Rezoning Transportation Analysis

Petition Number: 2023-039

From: Jake Carpenter, PE

Date	Description
7-26-23	First Review (IW)

RZ1-00

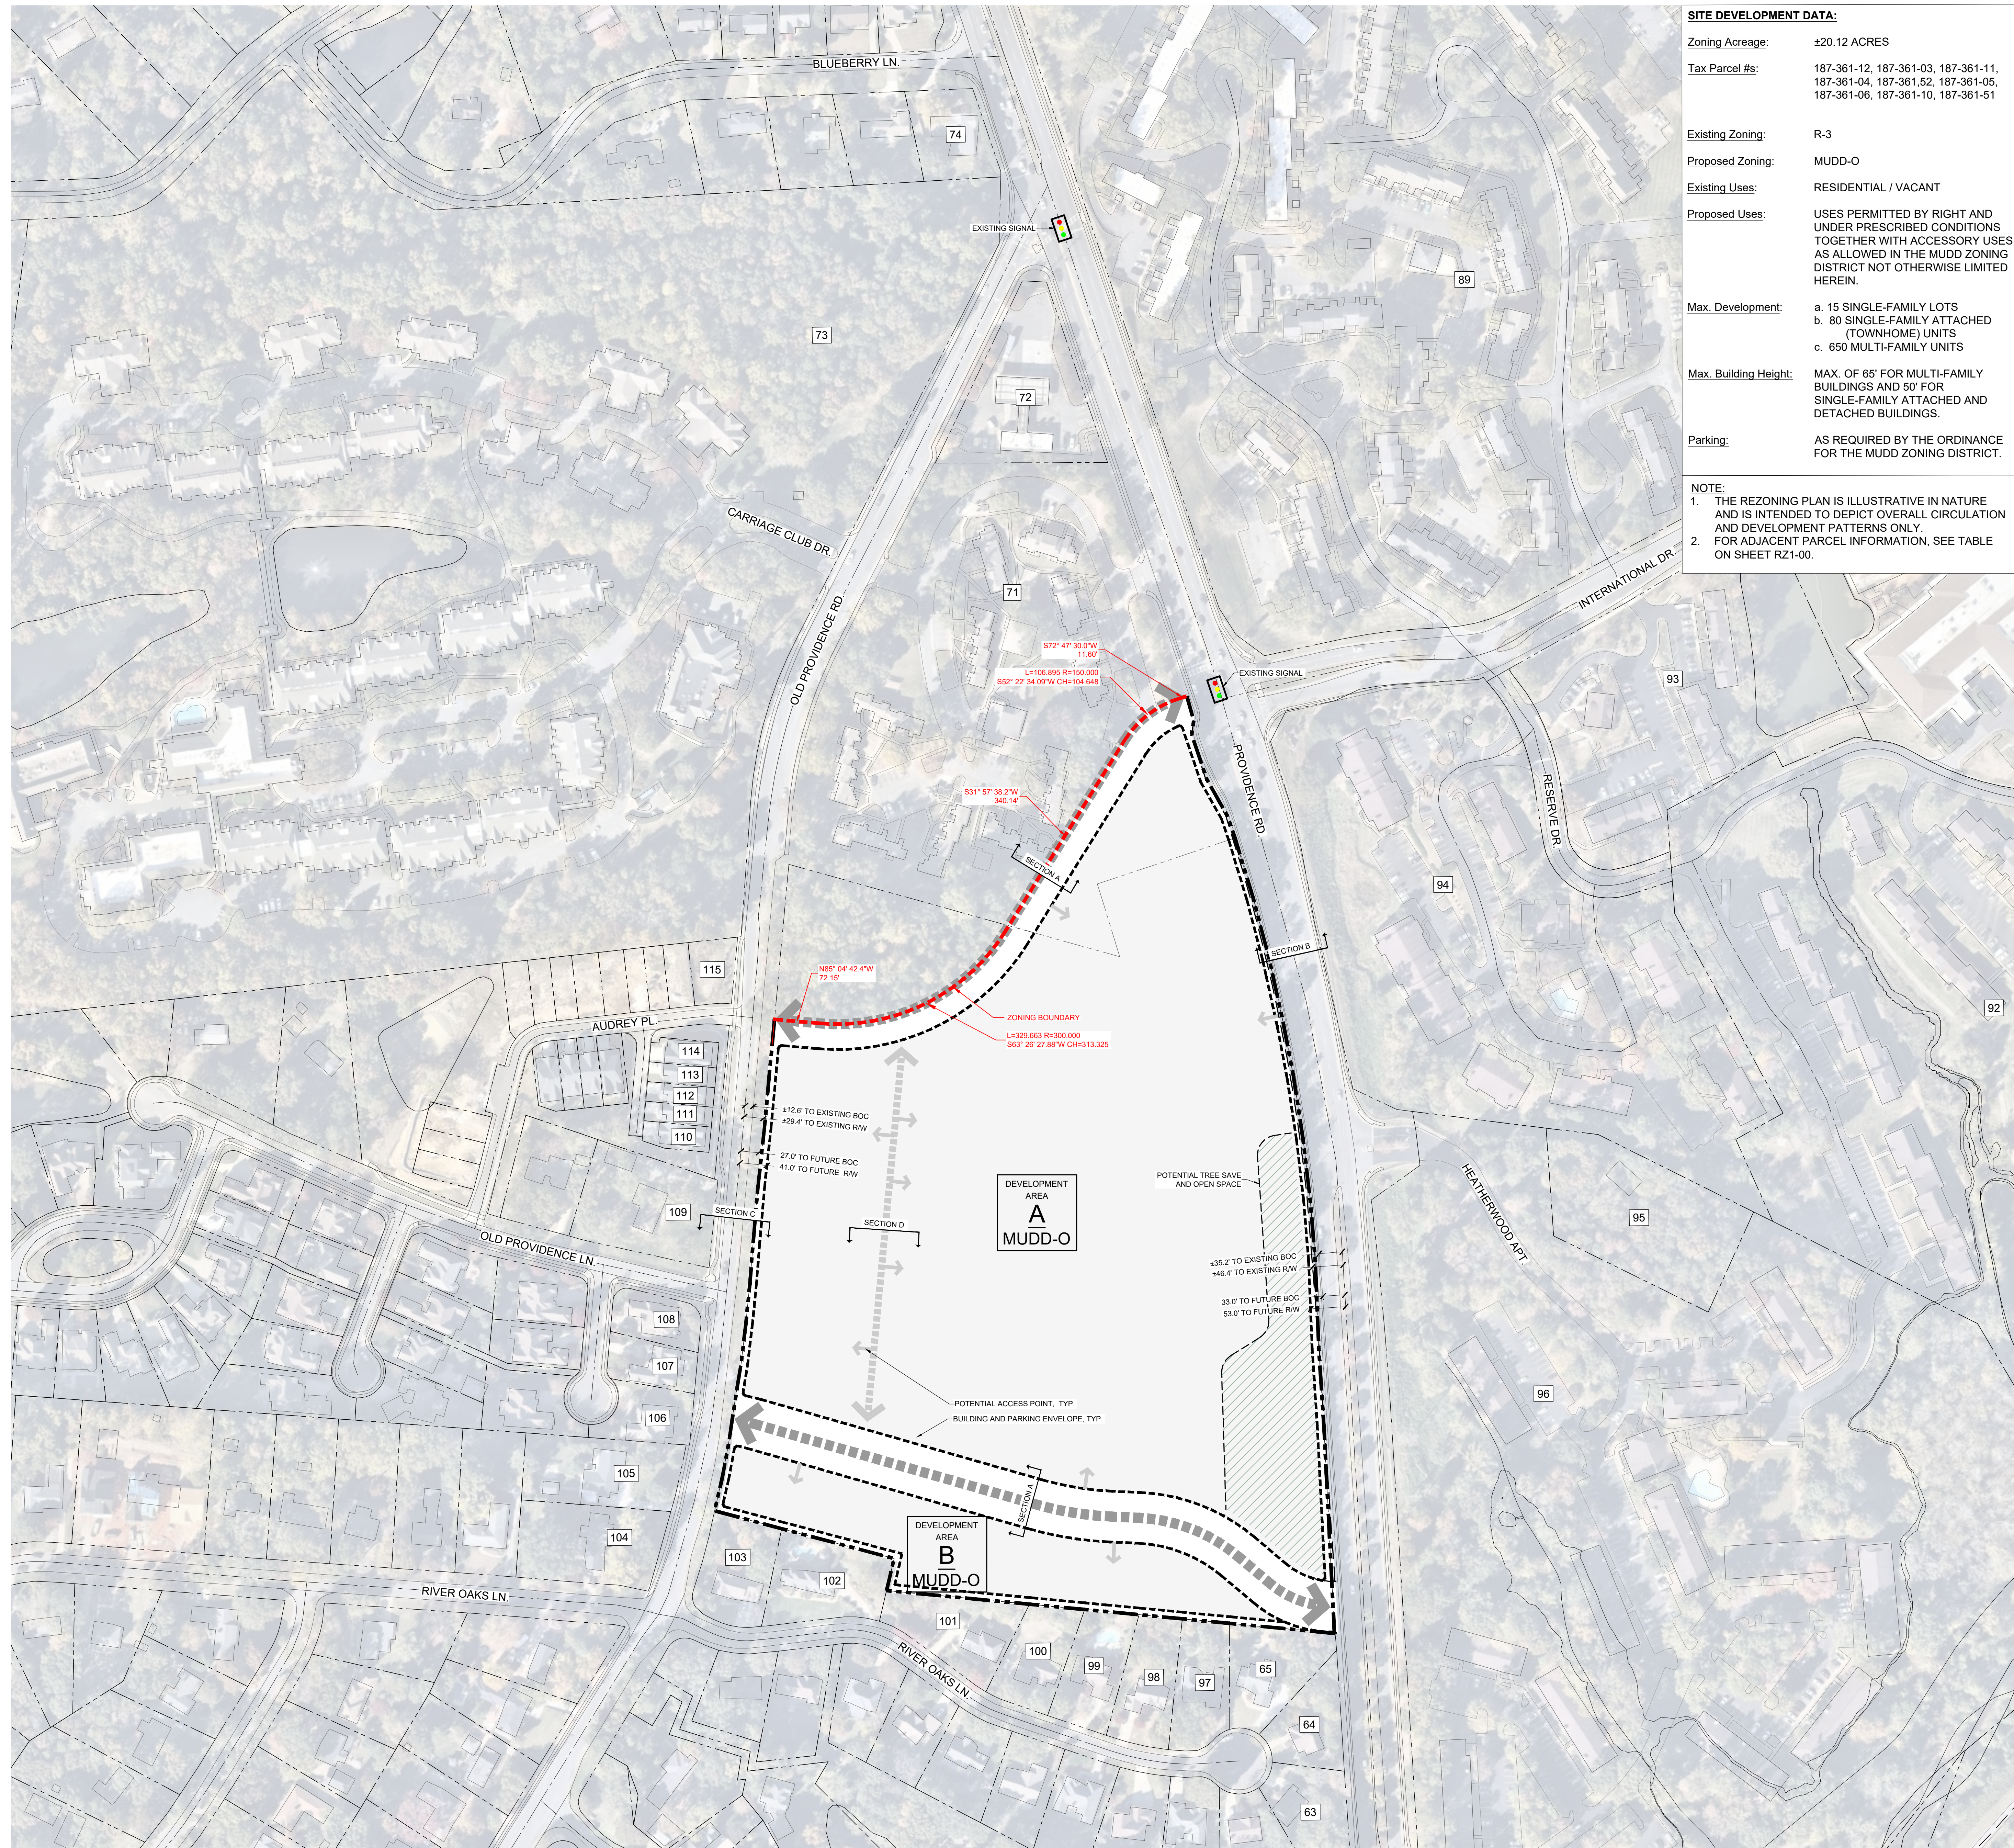
1. Curblines:

- a. **Providence Road:** Location of back of curb and gutter to be moved to 33 feet from roadway centerline to accommodate the Charlotte Streets Map with a roadway typical section of 4+ Boulevard, shared use path.
 - i. This dimension could change depending on mitigations resulting from the Traffic Study.
- b. **Old Providence Road:** Location of curb and gutter to be moved to 27 feet from roadway centerline to accommodate the Charlotte Streets Map with a roadway typical section of 2+ Avenue Buffered/Separated Bike Lanes.
 - i. This dimension could change depending on mitigations resulting from the Traffic Study.

Label and dimension the curb and gutter from the centerline for each road on the site plan.

4. Revise site plan and conditional note(s) to commit to dedicate 55' of right-of-way from the Providence road centerline. The site plan shall label and dimension the right-of-way from the road centerline.

- a. This dimension could change depending on mitigations resulting from the Traffic Study.
5. Revise site plan and conditional note(s) to commit to dedicate 43' of right-of-way from the Old Providence road centerline. The site plan shall label and dimension the right-of-way from the road centerline.

- a. This dimension could change depending on mitigations resulting from the Traffic Study
6. Revise site plan and conditional note(s) to commit to construct an 8-foot planting strip, and 12-foot sidewalk on Old Providence Road per the Council-adopted Charlotte Streets map and the Council-adopted Charlotte BIKES Policy. Multi-use paths maintained by the City shall meet ADA/PROWAG requirements. The site plan shall label and dimension both items from the back of curb and gutter or edge of pavement.

7. CDOT requests that the petitioner revise site plan and conditional note(s) to commit to extending the streetscape of 8' PS and 12' MUP on Providence Road to connect to the McAlpine Creek trail.

8. The proposed dwelling units exceeds 12 per acre. Per Chapter 20 Subdivision ordinance, revise site plan and conditional note(s) to commit to construct an 8-foot planting strip, and 8-foot sidewalk along Old Providence Road. The wider sidewalk also meets the Charlotte WALKS Policy.
